MEMORANDUM

SUBJECT: SF-18-008 – Lorson Ranch East Filing No. 1
Response to Comments - First Submittal

Final Plat

SHEET 9 OF 11

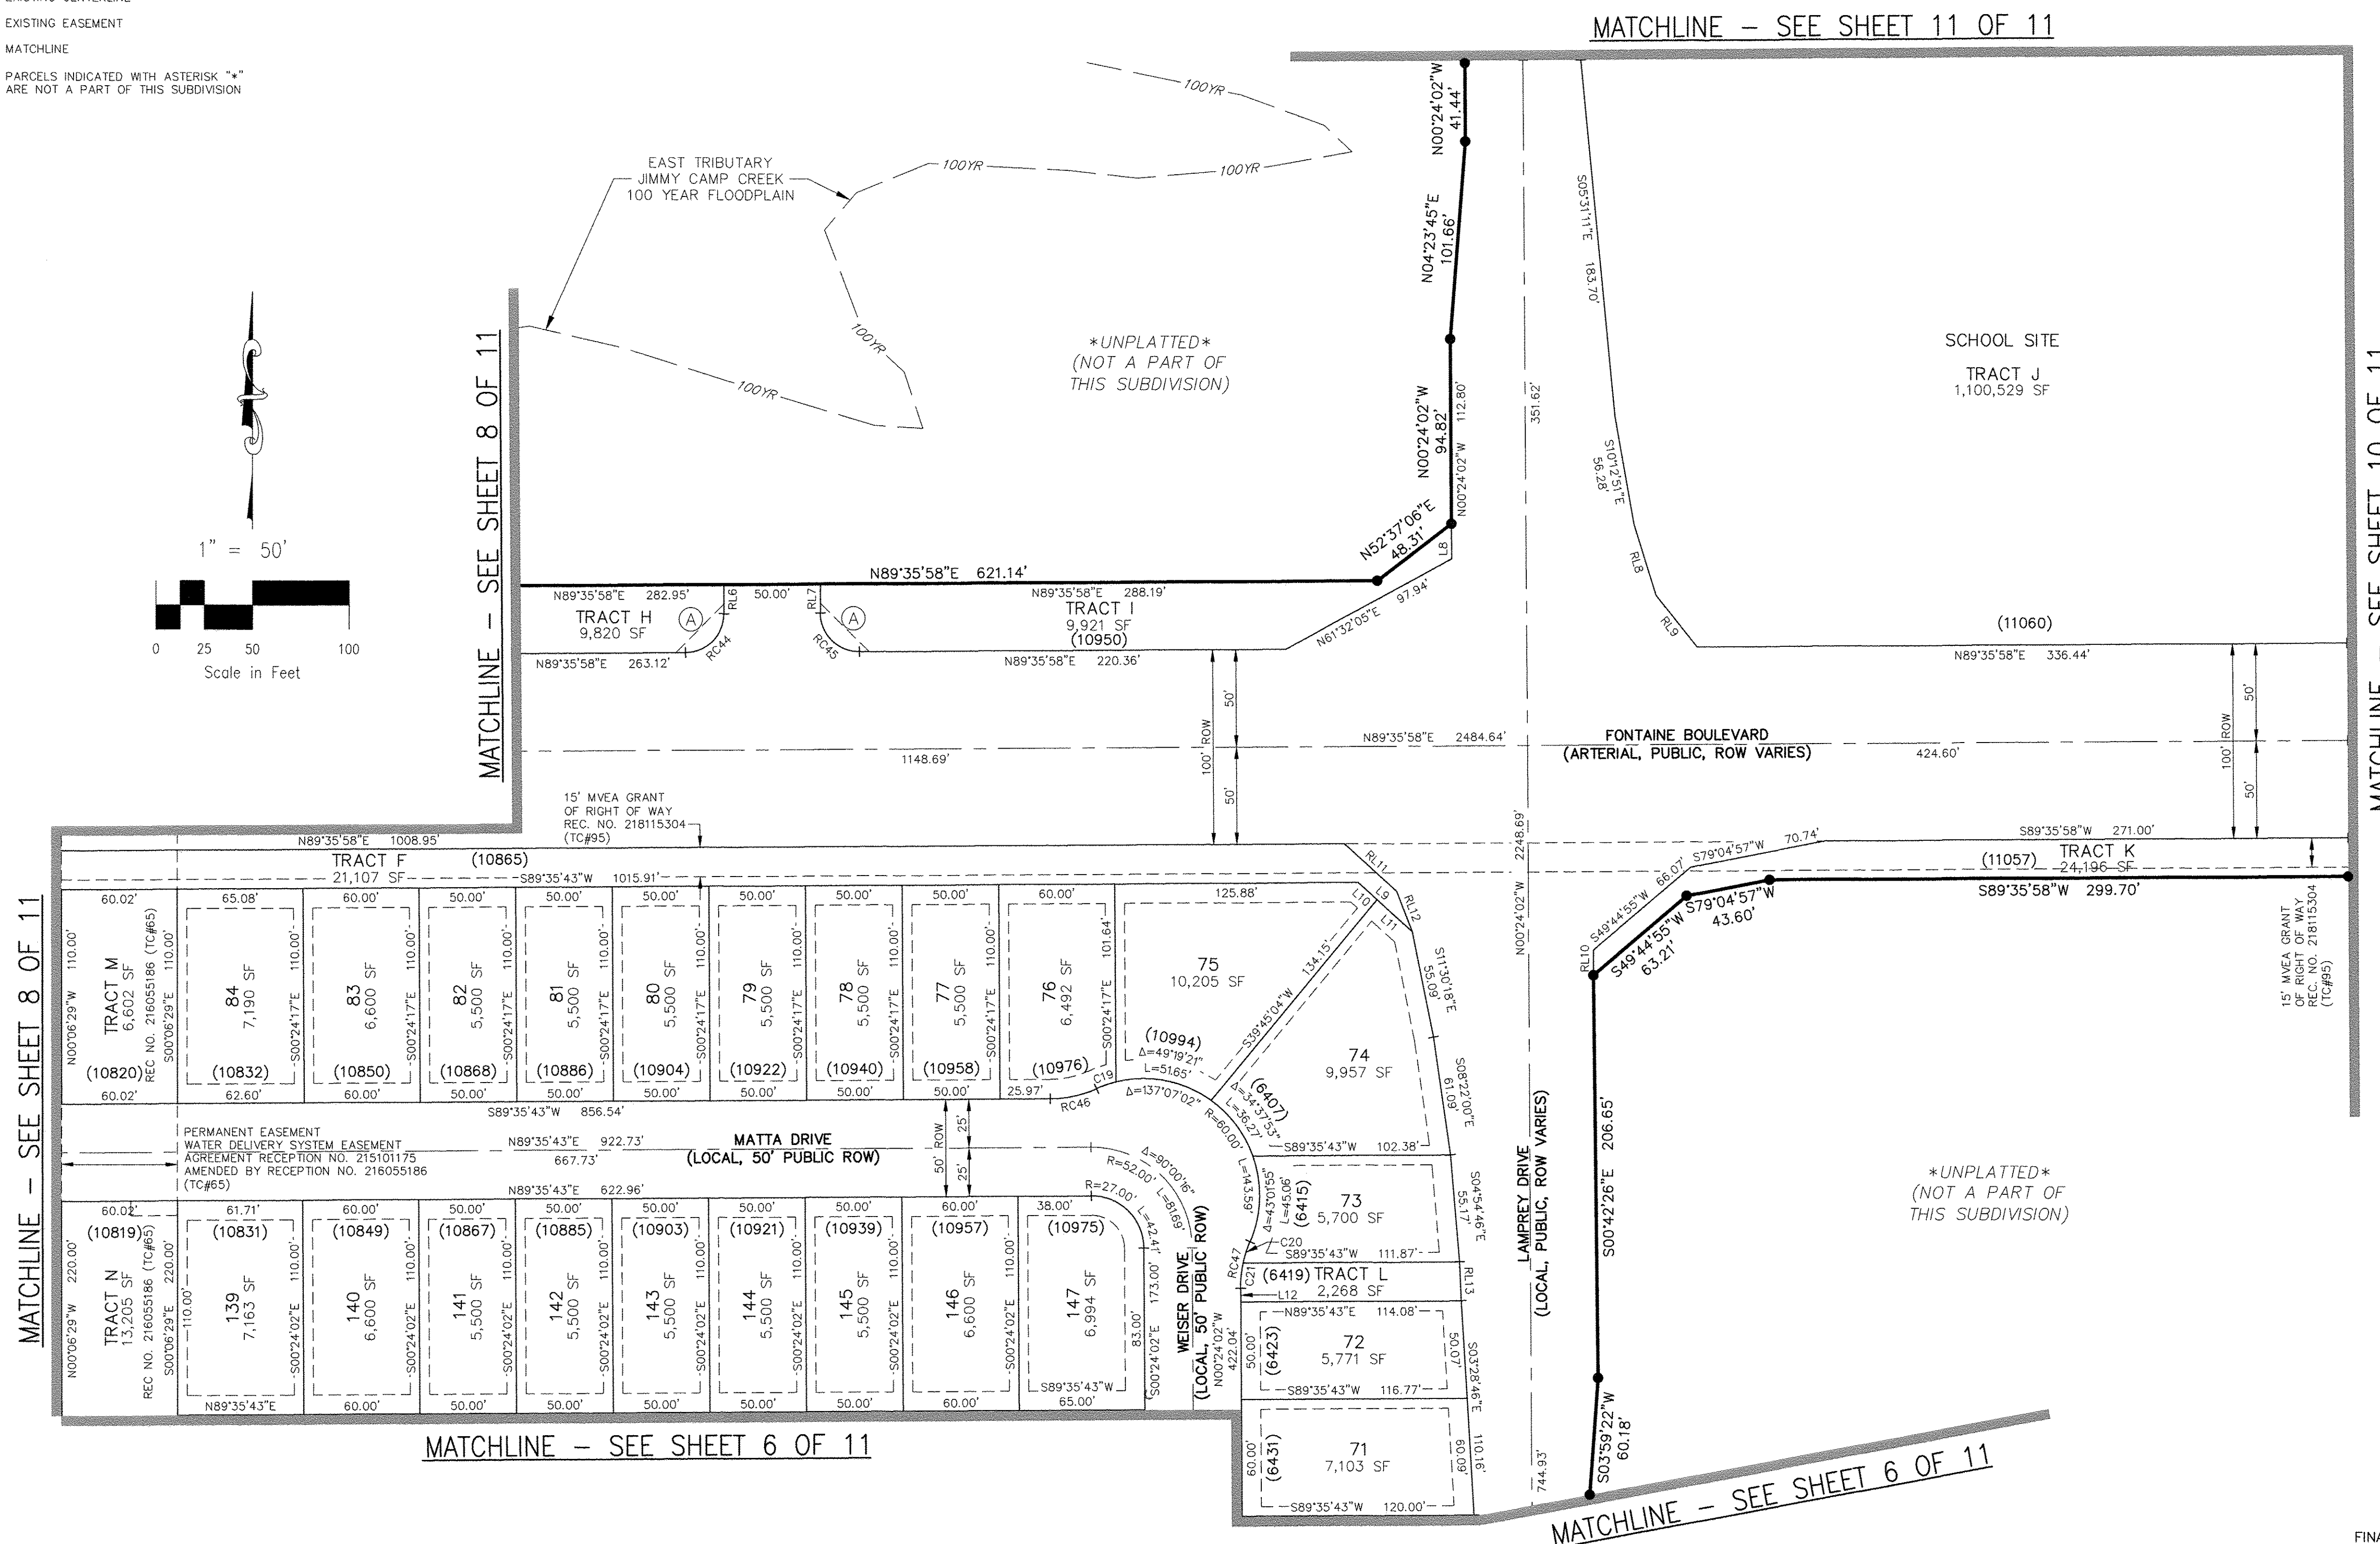
1. Provide documentation of separate easements and vacation/termination documents removing encumbrances on proposed rights-of-way, when available.
2. A segment of the Jimmy Camp Creek East Tributary north of Fontaine Blvd. needs to be included in this plat, with perpetual maintenance of the channel by the Lorson Ranch Metro District, since it serves the detention basin outfall.

5. Amend Note 19 to include Reception # 216055186.
6. Show and label the Permanent Easements granted under Reception Number 216055186
